5 April 2022

DESIGN INTEGRITY PANEL BRIEFING AND COMMENTS

On Wednesday 23 March 2022 Gurner and its consultants briefed the Design Integrity Panel in relation to the design changes arising between the PTW winning mixed use BTS tower and the proposed mixed use BTR tower.

4 3D VIEW - PODIUM FACADE DETAIL

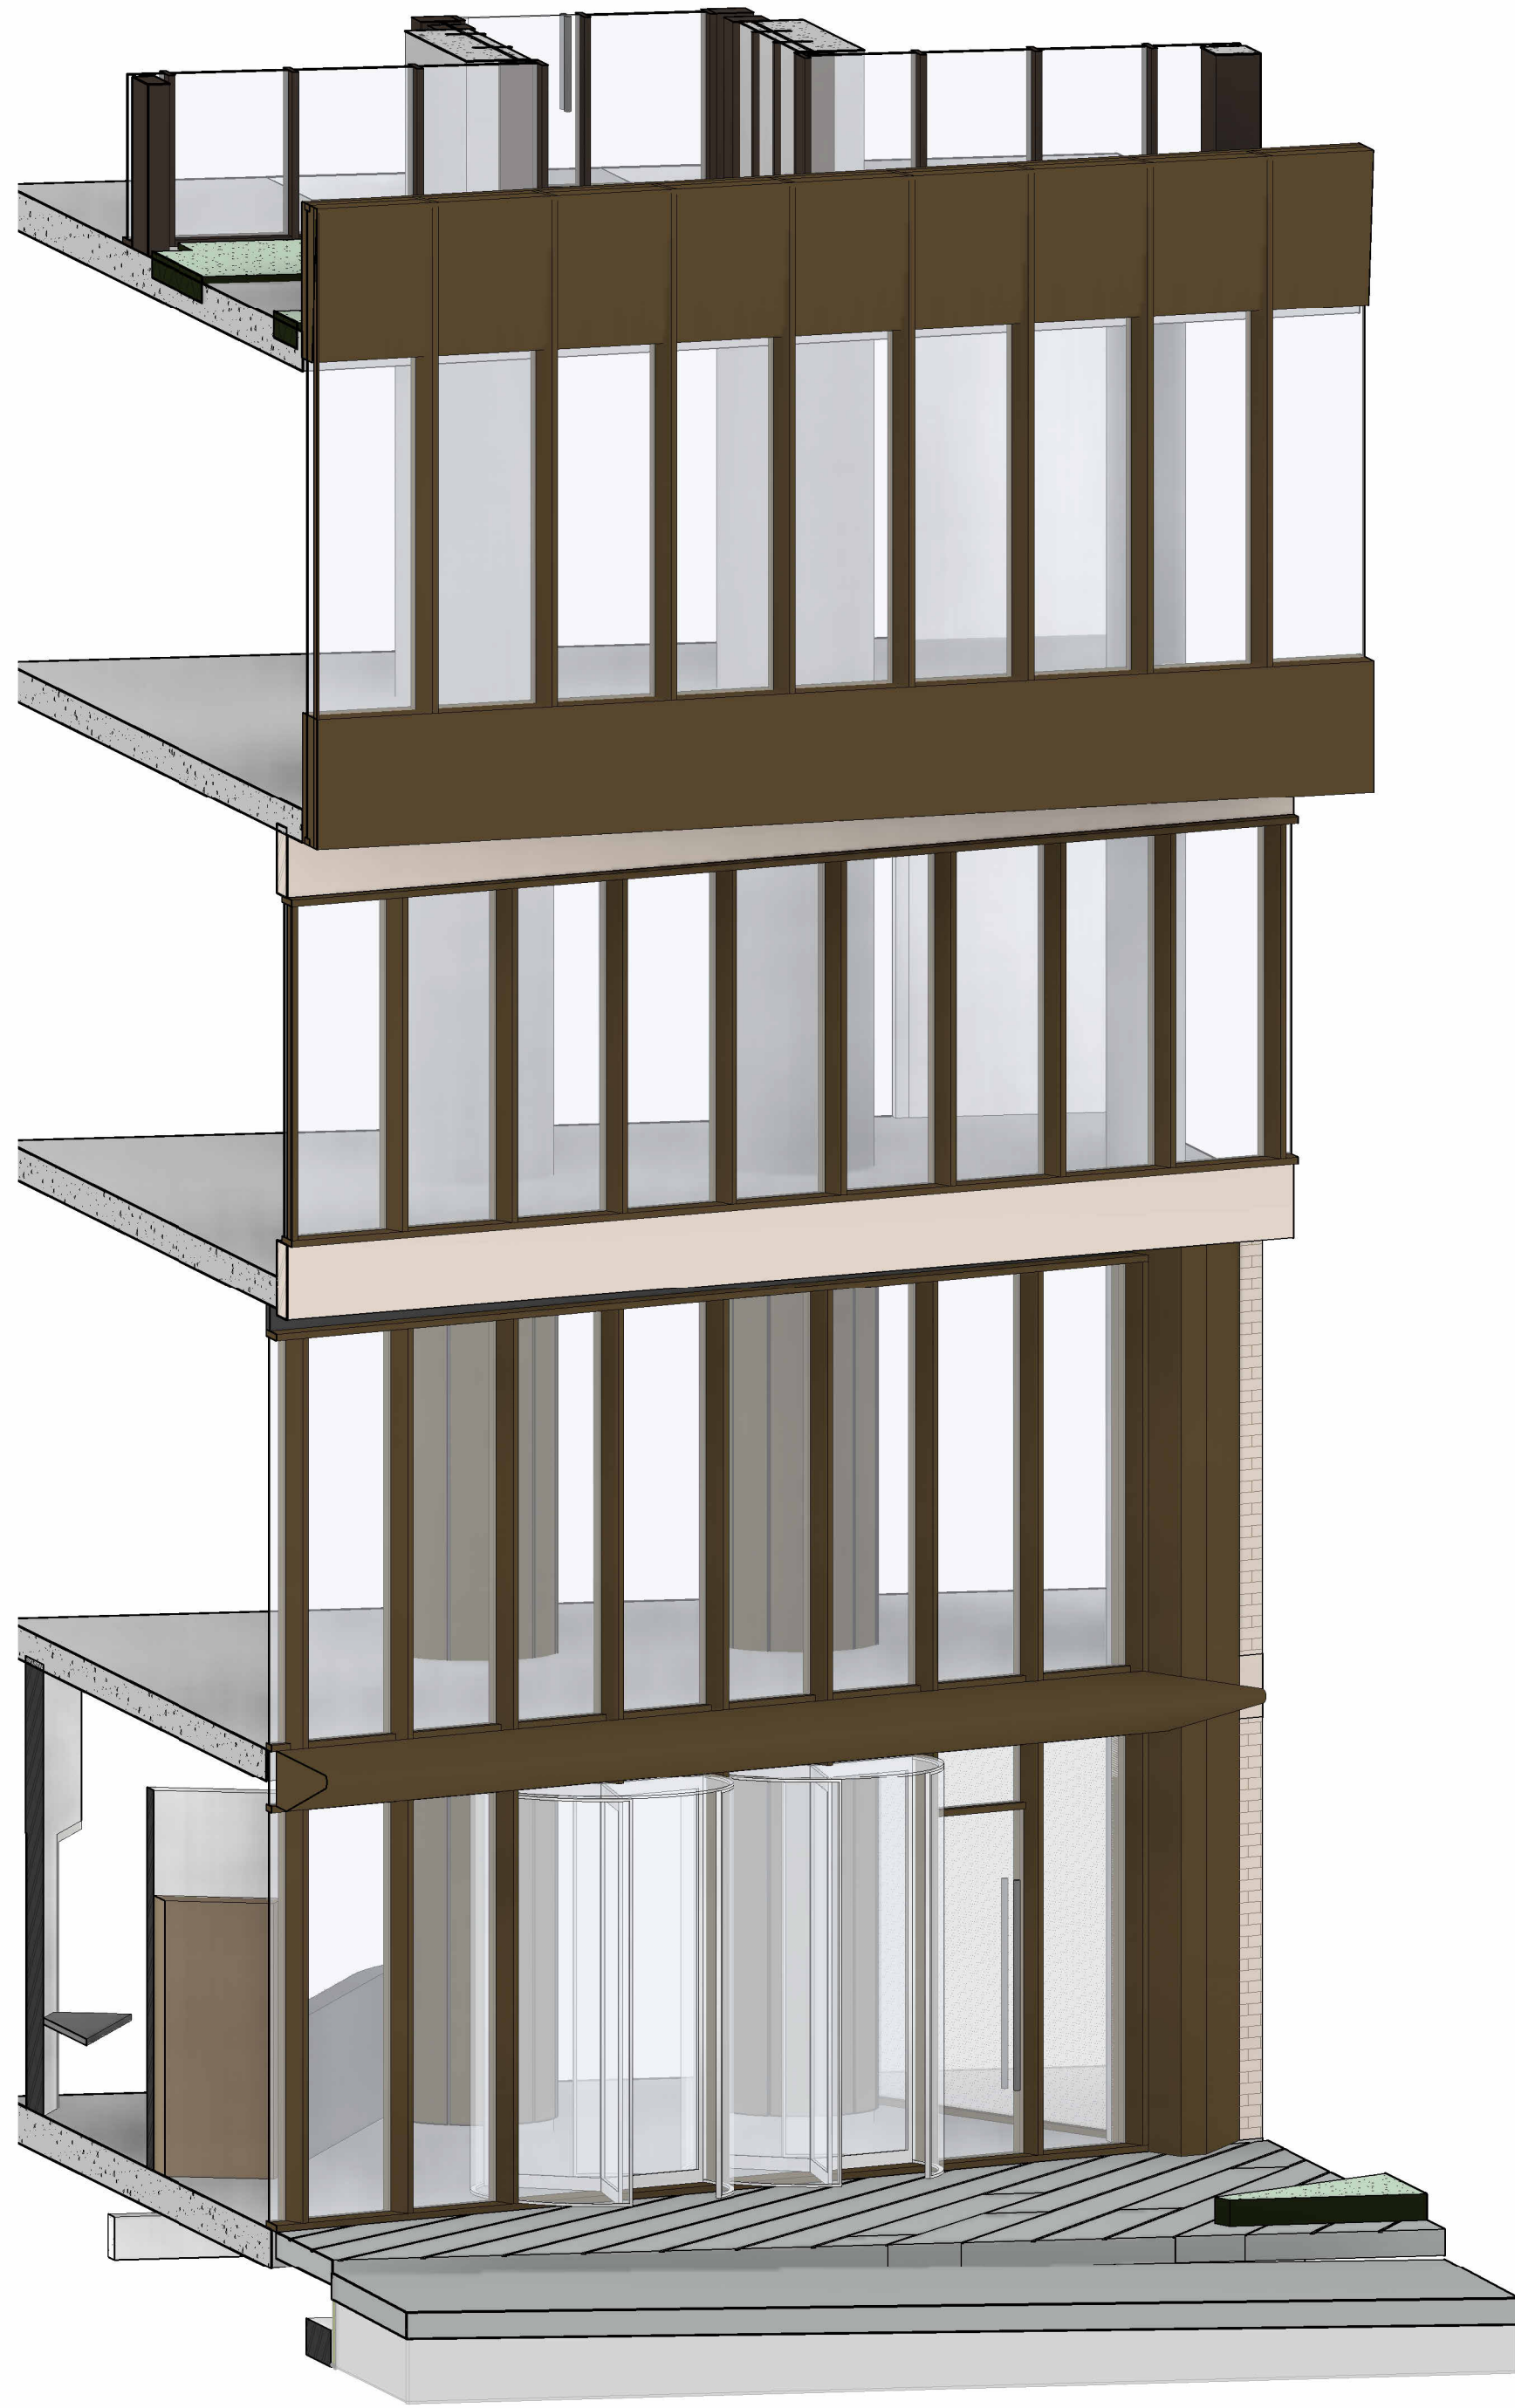
- Summarise the key changes to the podium. What are these changes and how has design excellence been retained?
- The podium design seems to comprise a higher level of glazing, please clarify and explain design implications.
